**DECISION DELEGATED TO HEAD OF PLANNING**

**Application No:** H09-0796-25                      **Applicant:** Loosegate Developments Ltd

**Proposal:** Proposed Erection of 2 Bungalows

**Location:** Land East Of Forest Way Holbeach Spalding

PROPOSED SITE PLAN
scale 1:200

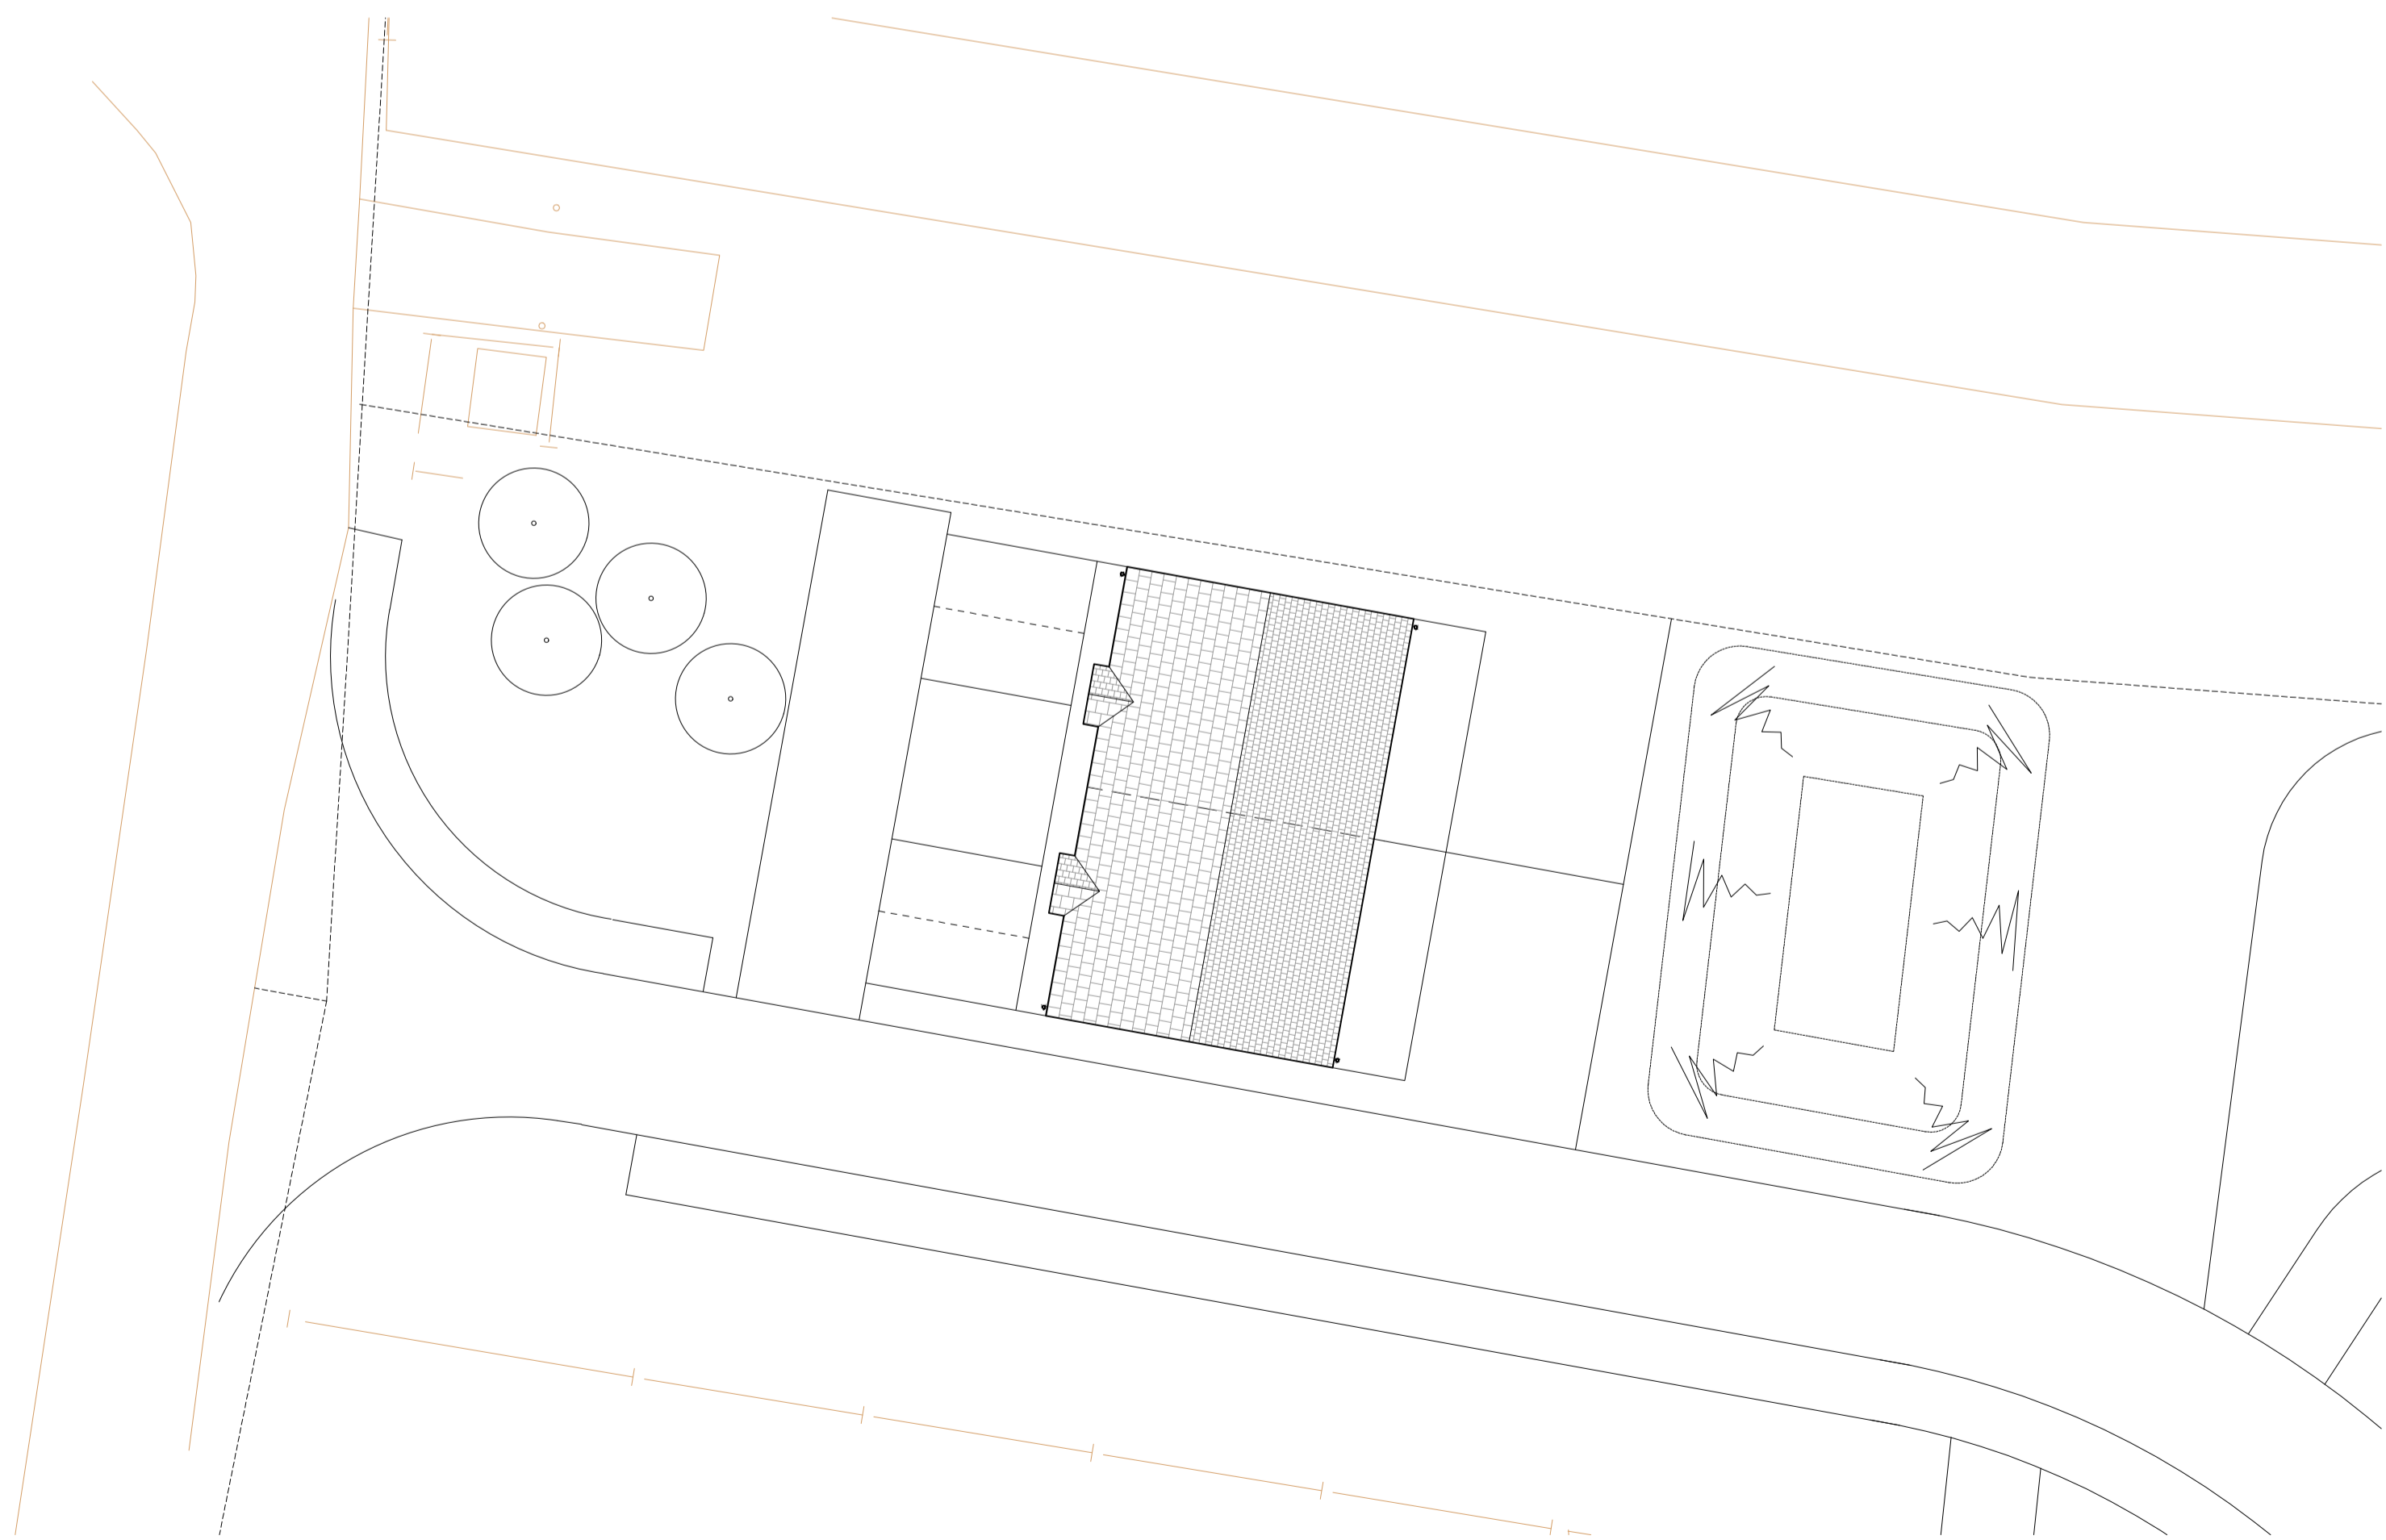
Lincolnshire County Council - Highways and SUDS: The dimensions of the private drive and parking spaces are to be detailed. The proposed dwellings are very close to the attenuation basin - how will the increase in permeable area affect the functionality of the basin? This should be taken into account by the LPA when they assess the drainage/surface water flood risk.

The bungalows are proposed to be located to the east of Forest Way, facing northwards towards Wignal's Gate. A driveway area and four parking spaces are proposed to the north of the bungalows and rear gardens are proposed to the south of the bungalows, next to an attenuation basin. As the bungalows face to the north, the side elevation of one of the bungalows would be located approximately 1.2m from the edge of the access road. A blank side elevation is proposed. Due to the proximity of the side elevation to the road and the blank elevation that is proposed, it is considered that this would result in a poor addition to the street scene, resulting in a harmful impact to the character and appearance of the area.

There is no strict uniformity in terms of the nearest plot layouts. There are also no dwellings directly next to the site. There are two bungalows located to the south-west of the site, on the opposite side of Forest Way. These bungalows include 2 Forest Way and 4 Forest Way. Both of these bungalows face to the east, towards Forest Way and are set back from the road frontage. As such, both bungalows have front gardens and are set within appropriately sized plots. The proposed bungalows, by contrast, would feature a more cramped layout due to their proposed siting. Therefore, it is considered that the development represents a cramped layout, representing an incongruent form of development that would be out of keeping with the character and appearance of the area.

The submitted plans do not show any indicative landscaping; however, there is limited scope for soft landscaping due to the small size of the site. Whilst the approved soft landscaping has not been planted within the site, the site still contributes to the character of the street scene, providing an entranceway to the wider site. The combination of the cramped layout, the lack of soft landscaping and the blank frontage on the side elevation that is located only 1.2m next to Forest Way results in a poor-quality design.

Due to the proximity of the site to an attenuation basin, it is also unclear if the development could undermine the drainage scheme for the wider site. The approved drainage strategy for the wider site took into account the permeable and impermeable areas within the site. The proposed bungalows would introduce further built development and it is unclear if this could affect the wider drainage strategy by increasing the water storage requirements for the area.

LCC's highways and sustainable drainage team have queried whether the proximity of the dwellings to the attenuation basin is suitable. For example, it is unclear if the increase in the permeable area could affect the functionality of the attenuation basin. This has been queried with the applicant's agent, however, no additional information has been provided to demonstrate that the proposals would not undermine the functionality of the basin. Condition 7 of permission H09-0326-17 required surface water drainage details to be submitted and agreed for the wider residential development site which now includes 79 dwellings. Condition 7 was discharged under reference H09-0228-19 on 25 April 2019. The approved drainage strategy included a combination discharging surface water from roofs into soakaways and from the access road into the South Holland Internal Drainage Board system to the east of the site via two separate outfalls. The outfalls have a restricted discharge rate of 5 litres per second. It is unclear if the proposed additional dwellings would affect this discharge rate.
